# CITY OF ALBUQUERQUE

**Re: Hubbell Heights Shops Conceptual Grading and Drainage Plan  
Engineer's Stamp dated 10-6-04 (K11/D71)**

**Re: Hubbell Heights Shops, Site Development Plan**  
**Engineer's Stamp dated 5-13-05 (K11-D71)**

CONCEPTUAL GRADING AND UTILITY PLAN

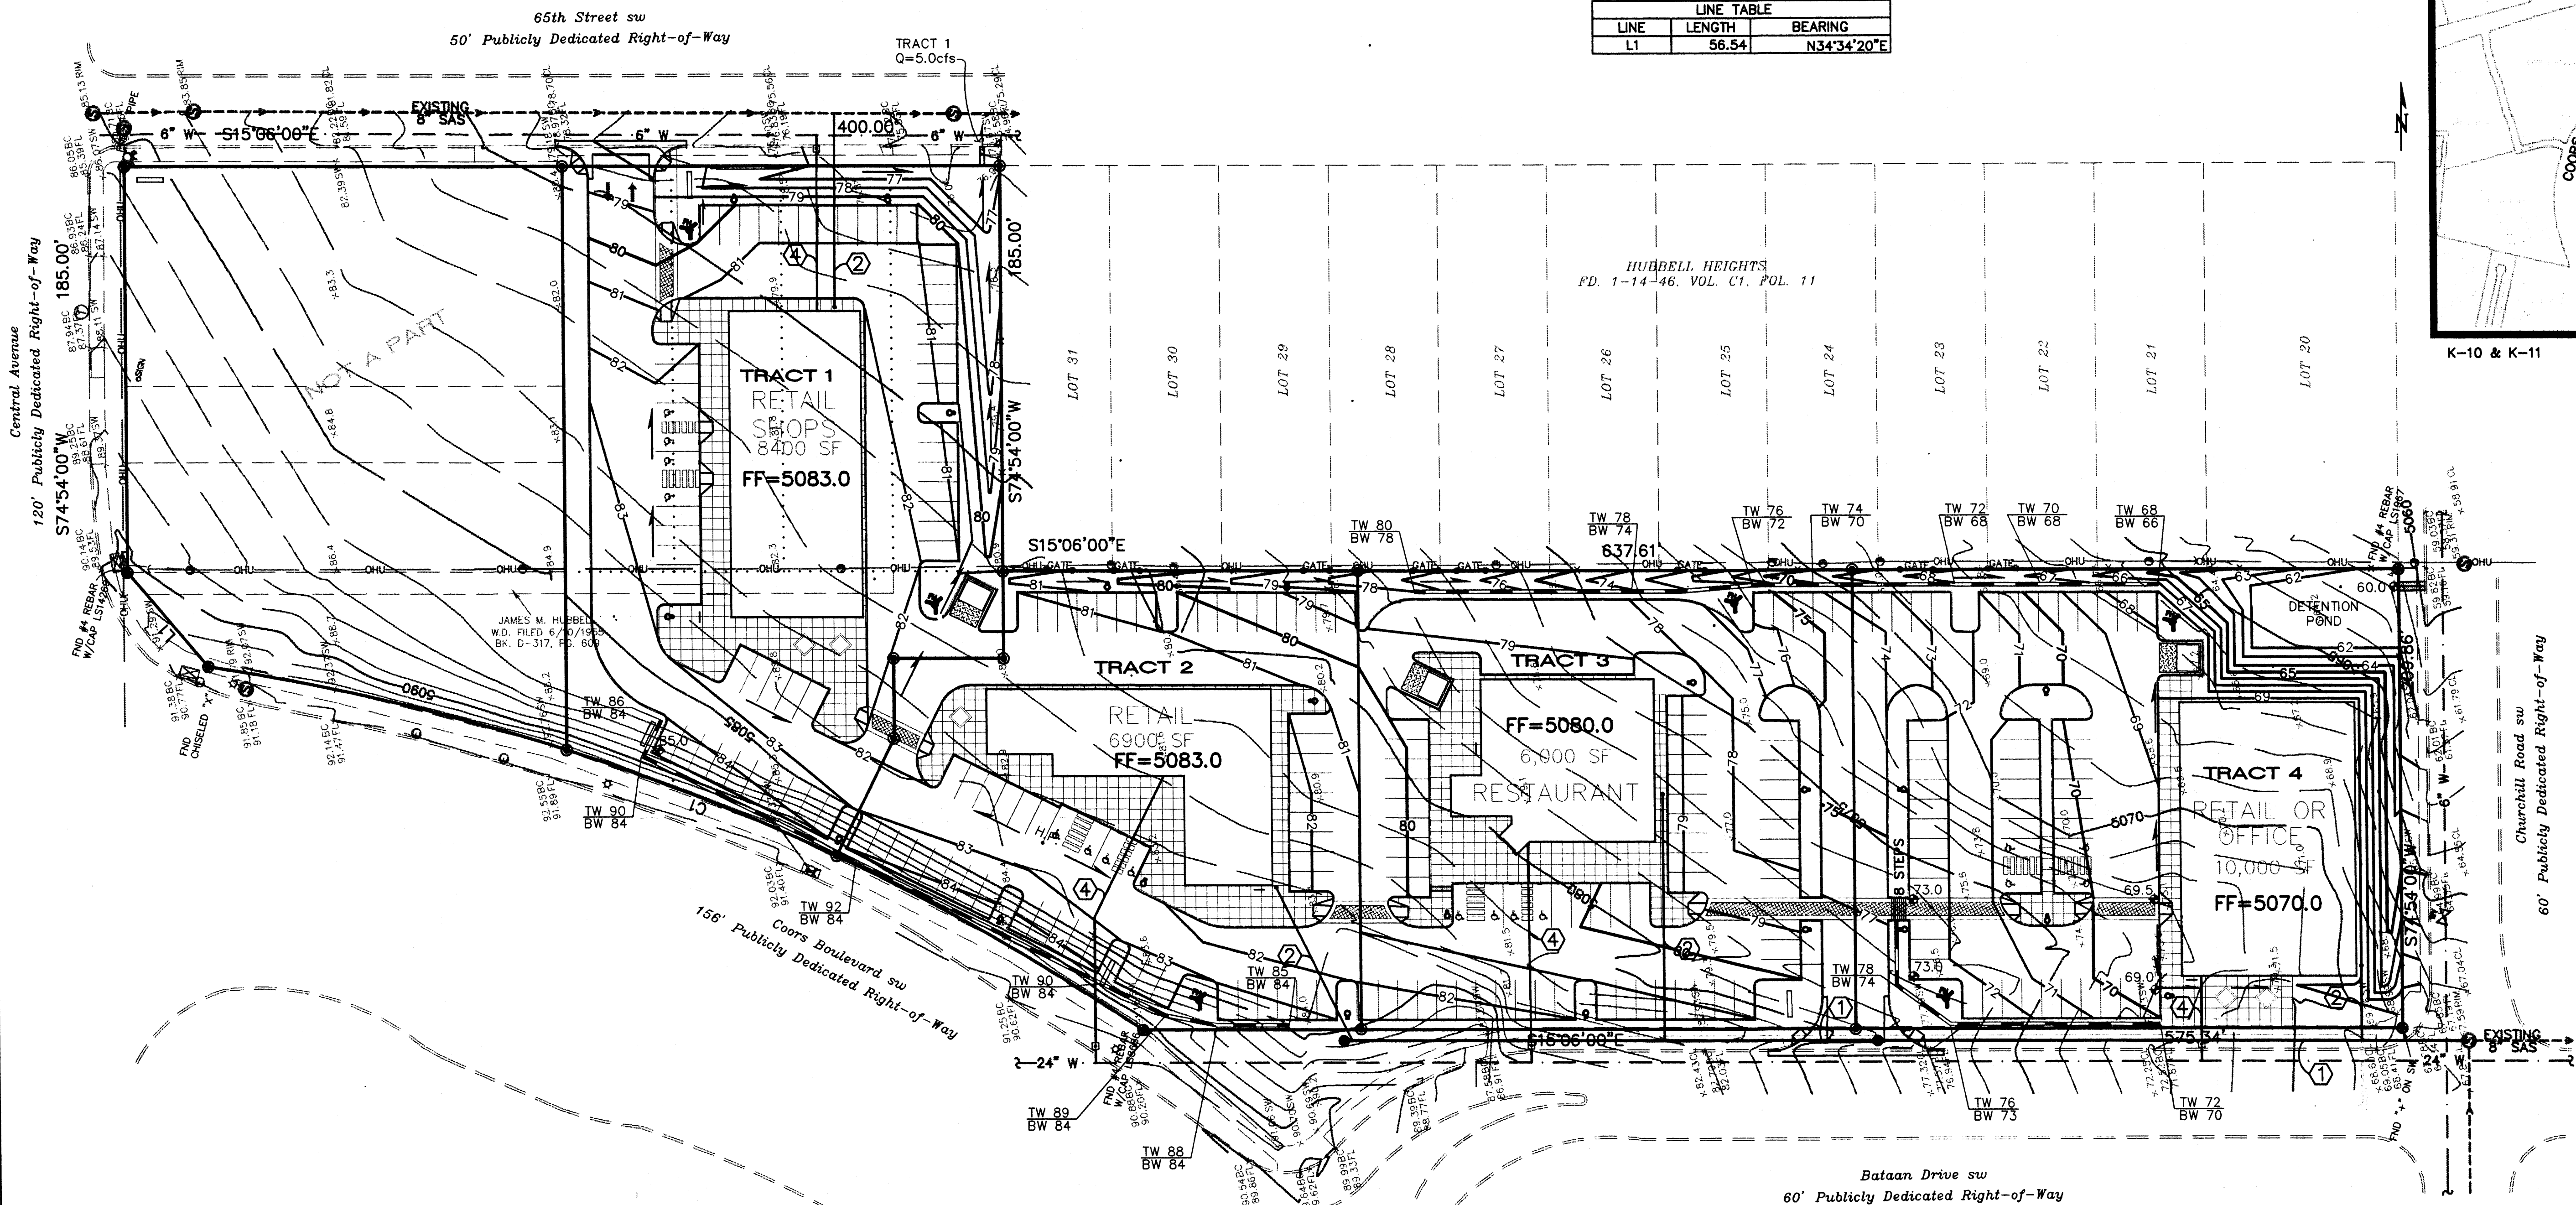
Based upon the information provided in your submittal dated 10-19-04, the above referenced plan is approved for Site Development Plan for Subdivision and Site Development Plan for Building Permit. Prior to Building Permit approval, please submit a plan addressing phasing, provide all critical spot elevations and give calculations of all hydraulic structures required.

CONCEPTUAL GRADING AND
UTILITY PLAN

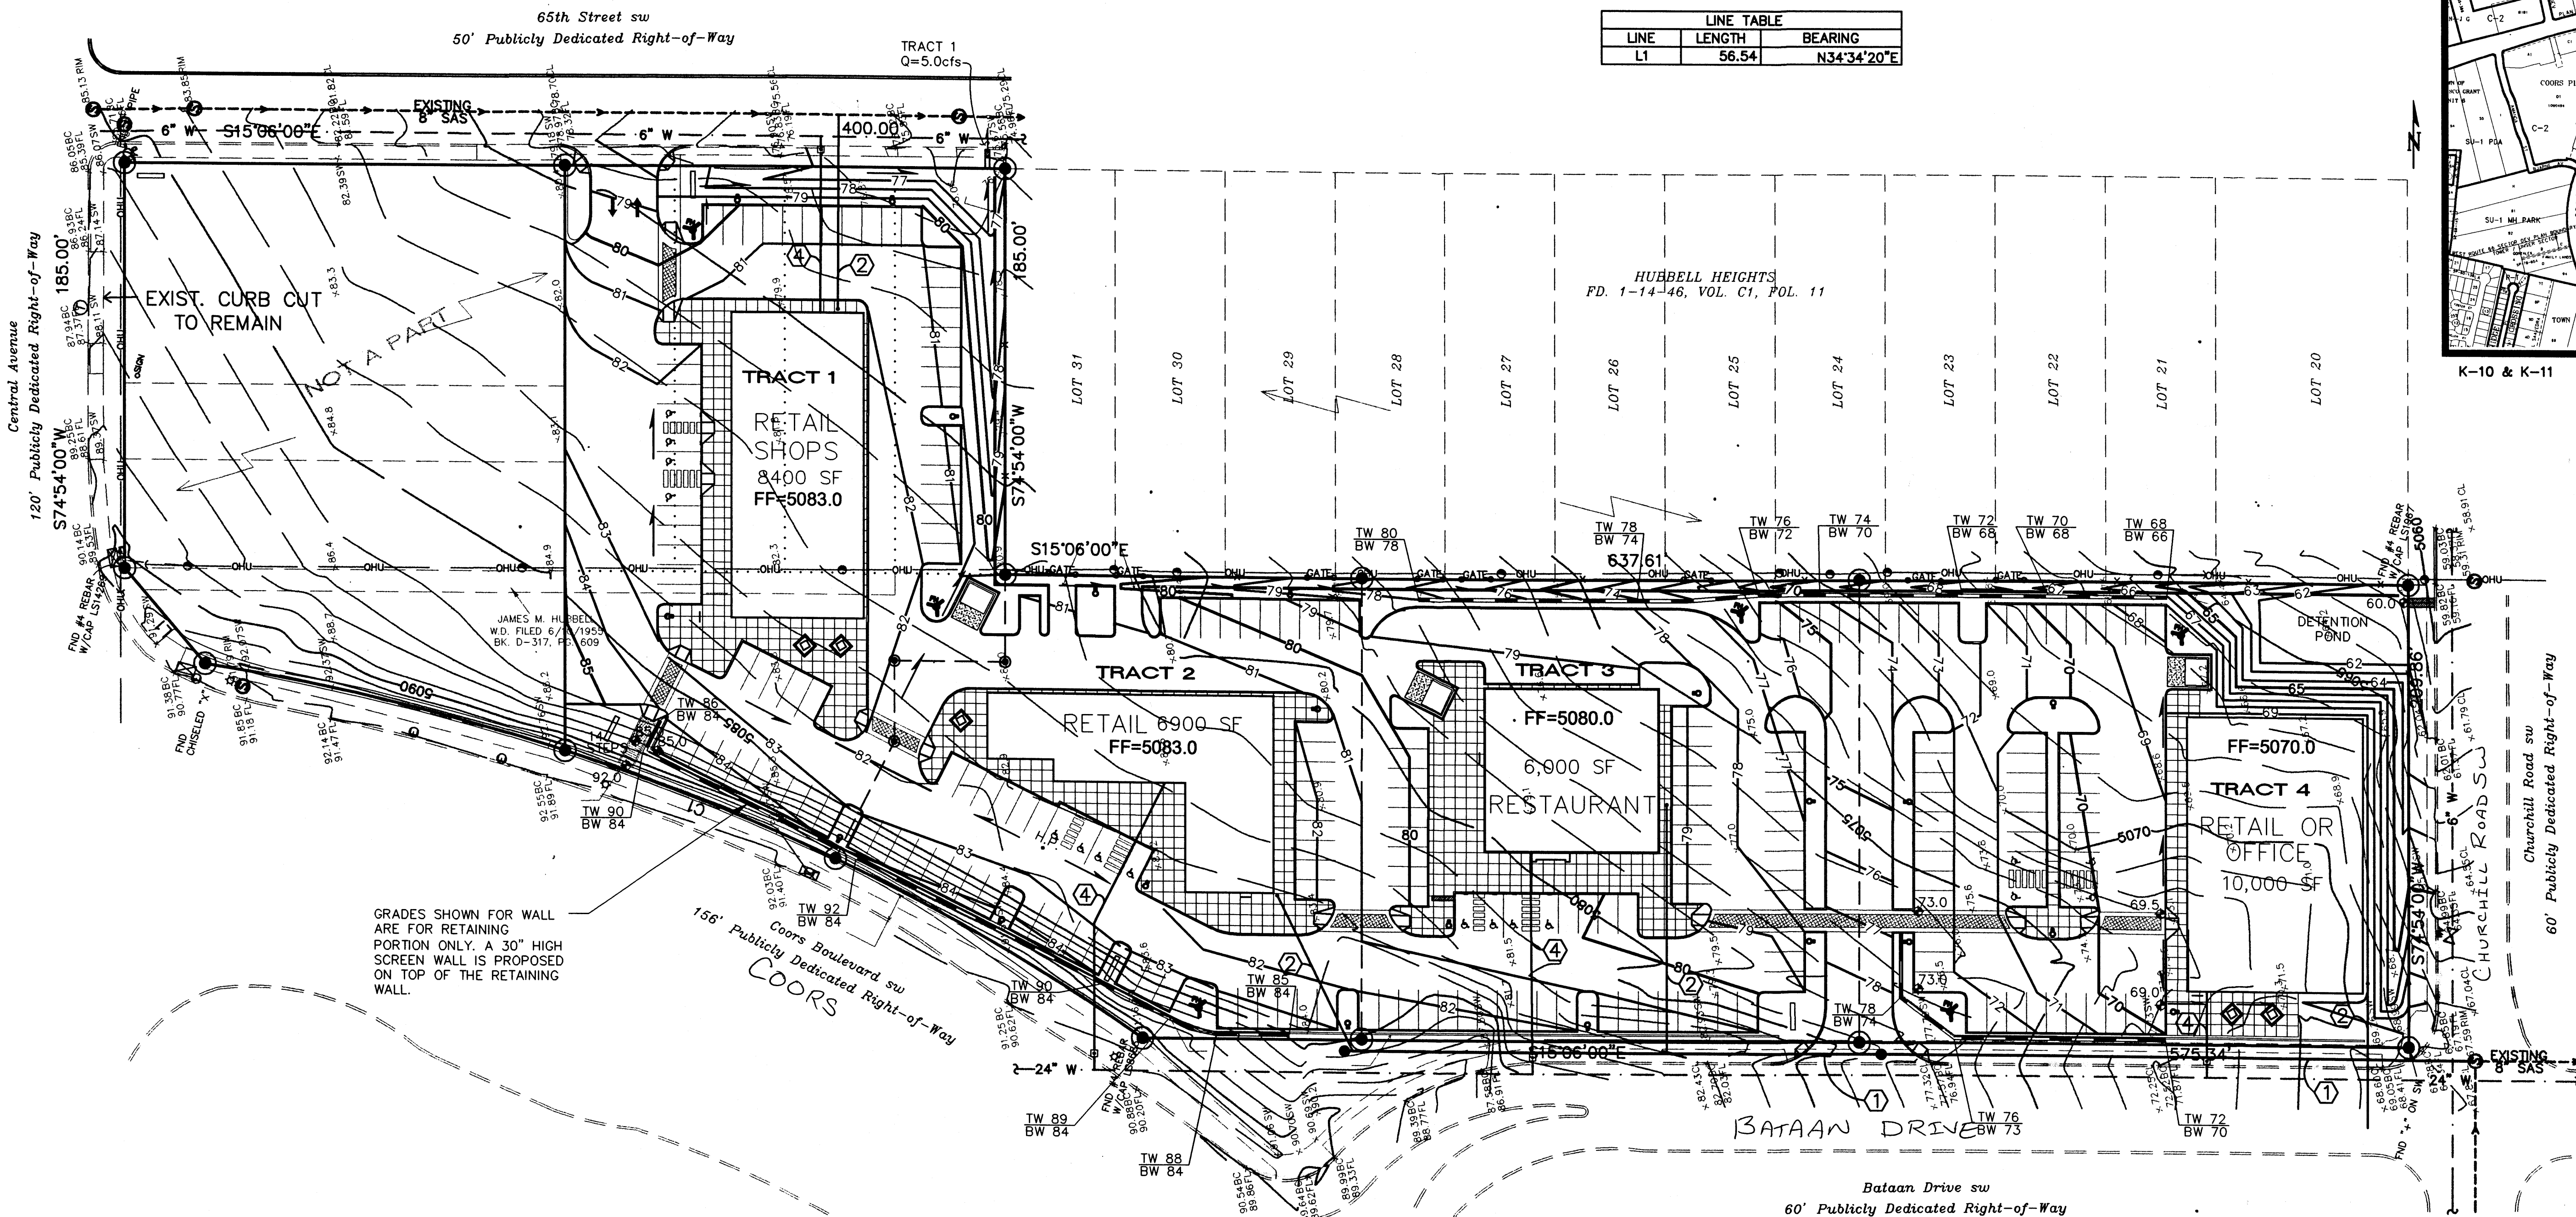
1. An SO#19 permit will be required for this project. Please include the appropriate notes on the grading and drainage plans, and provide two copies of the plan at the next submittal.
2. Will this project be built in phases? If so, you must provide drainage details for each phase.
3. Build notes and drainage calculations must be provided for all drainage structures, including the proposed detention pond.
4. Provide critical spot elevations.
